# One Earth Solar Farm

**Draft Statement of Common Ground with the Environment  
Agency**

**EN010159/APP/8.11.2**

November 2025

Appendix B Example Trenchless Crossing Cross-Sections

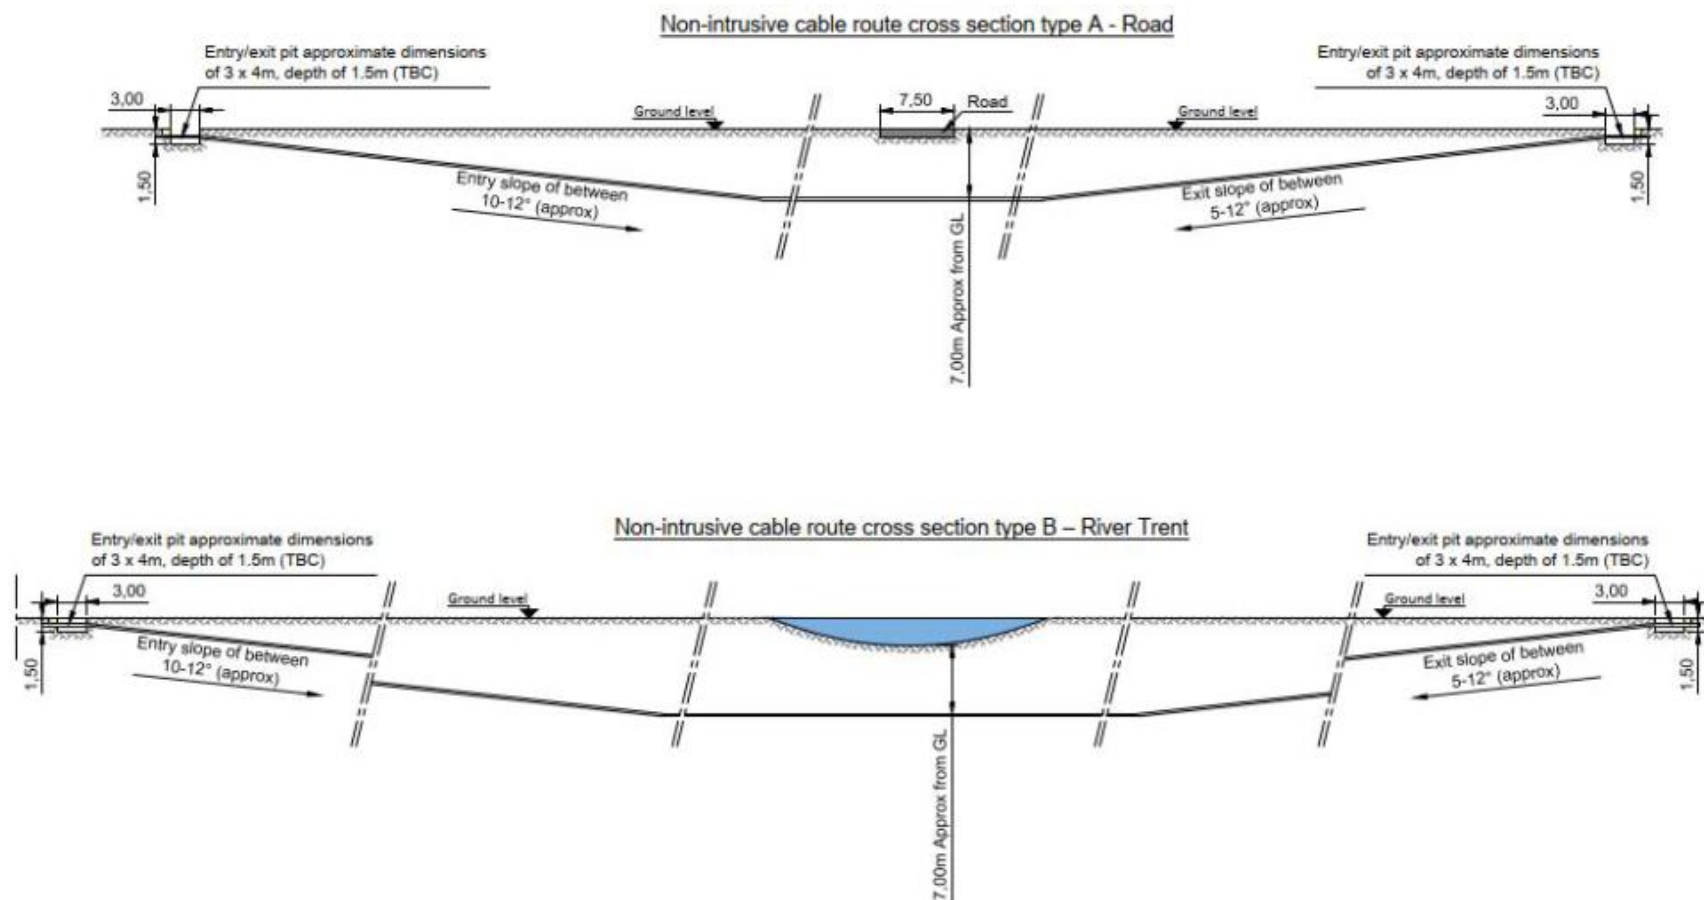
02-07	Cable Crossings beneath Main Rivers	Applicant to consider the impacts of cable crossings beneath Main Rivers and existing flood defences.	<p>The proposed cable crossing beneath the River Trent will be undertaken using trenchless techniques and specific construction processes will be set out within the CEMP.</p> <p>A hydromorphology survey, river bed survey and hydrogeological risk assessment to be undertaken to inform the design of the cable crossing beneath the River Trent.</p> <p>Surveys of the existing flood defences will be undertaken at detailed design if deemed required. Furthermore, monitoring of the flood defences can also be undertaken during construction if deemed necessary.</p>	Agreed
02-08	Maintenance Plans	Applicant to set out outline maintenance activities that will be undertaken to ensure there is limited potential for blockages to floodplain and the development maintained adequately.	<p>Specific maintenance required for the panel frames and inverter structures (following a flood event) will be set out at detailed design and included in the OEMP. However, likely to include the following as a minimum:</p> <ul style="list-style-type: none"> <li>• Clearance of any debris collected on fences, paths, roads and between panel supports.</li> </ul>	Agreed
